OXFORDSHIRE COUNTY COUNCIL'S RESPONSE TO CONSULTATION ON THE FOLLOWING DEVELOPMENT PROPOSAL

Application no: 15/00831/F

Proposal: Proposed development of a new Waitrose food store with car parking and access arrangement onto Southam Road. Demolition of existing building.

Transport

Revision:  
**T1**

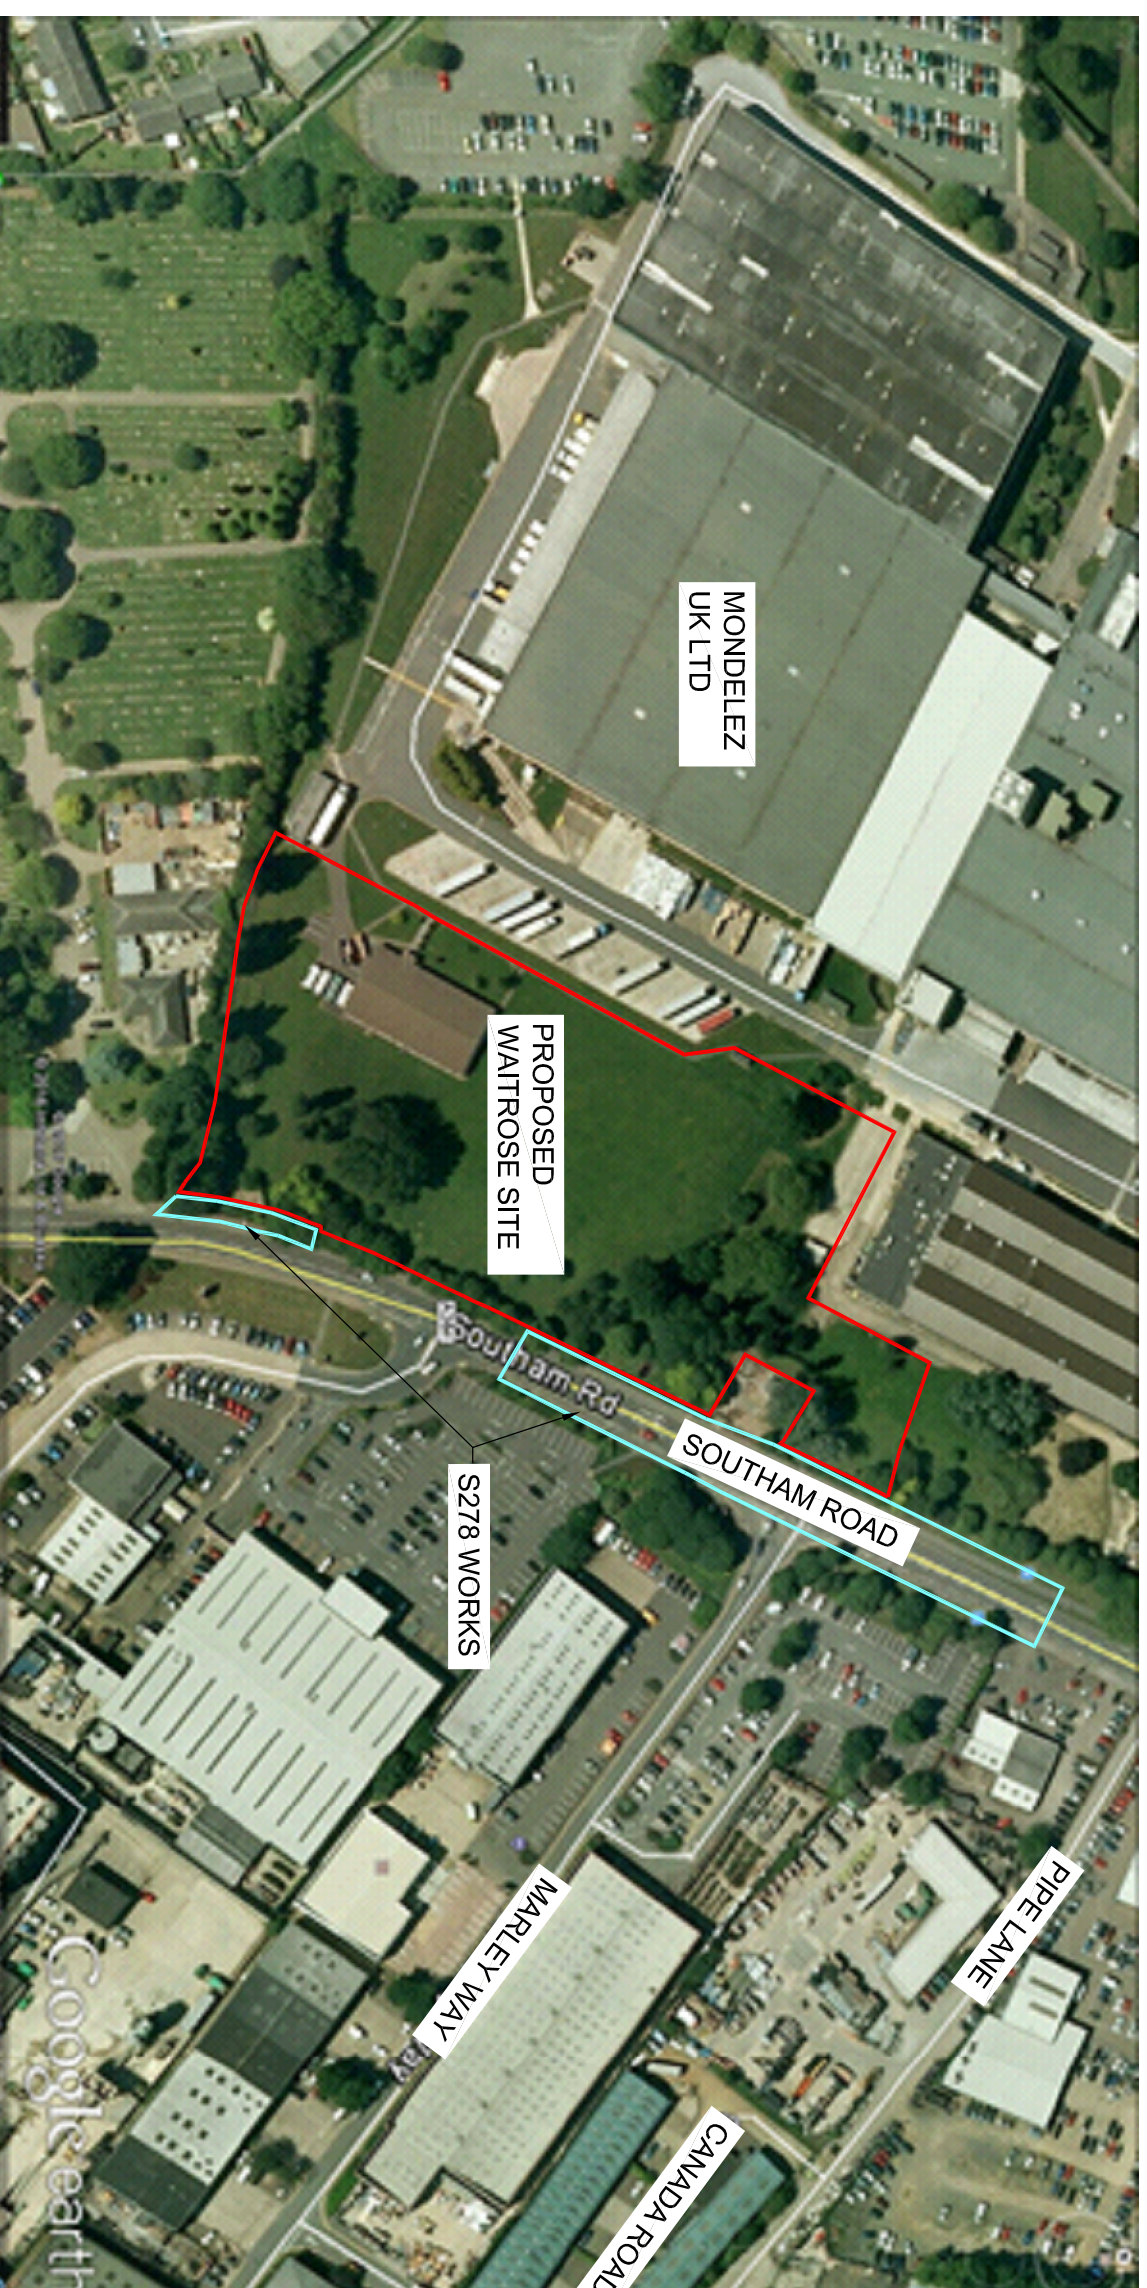
The safety audit also mentions the need for widening the right turning lane but it is not clear how this would impact on the on-carriageway cycle lane on the east side of Southam Road. The access arrangements drawings are not particularly clear and do not show how the new road markings would tie in with existing features.

Tracking has been shown for the new goods vehicle access - this does not include right turning in and out. The access road appears to continue beyond the store's service yard towards the Kraft site and I have concerns that it could be used for additional traffic. It is noted that the proposed goods access does not include a right turning lane and the junction has not been modelled. It is noted that the TA does not include details of goods deliveries.

I also have concerns about the impact on cyclists using the shared facility on the west side of Southam Road. Both vehicle access junctions are very wide and could be difficult to cross. The design could potentially incorporate a splitter island, though this would need to be wide enough for cycles. Given this is a strategic cycle route linking residential areas to the north of
